ADC PARKS & GREENSPACE ARBORICULTURE

PLANNING APPLICATION: AW/204/15/TC

ADDRESS: Tingewick 27 The Drive Aldwick PO21 4DU

BRIEF DESCRIPTION: Fell 1 No. Silver Birch tree & 1 No. Pittosporum tree within the Craigweil House Conservation Area.

TREE LAYOUT AT 27 THE DRIVE ALDWICK, PO21 4DU

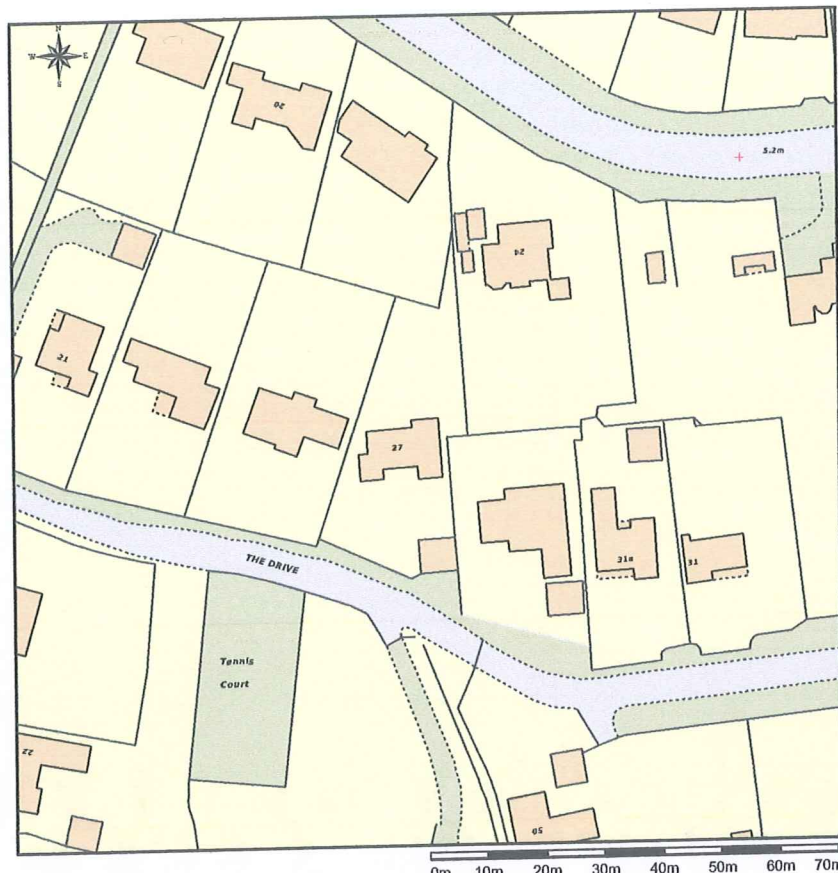
- The trees cited in this application are standing in the front and rear gardens of 27 The Drive. **T1** is easily visible from the highway outside; **T2** is not visible from the highway outside.
- From the site inspection it is clear that **T1** and **T2** are dead standing specimens. They are therefore not suitable for TPO orders.

- As both **T1** and **T2** do not have the attributes to warrant TPO orders, I would have no objection to the felling of both specimens.
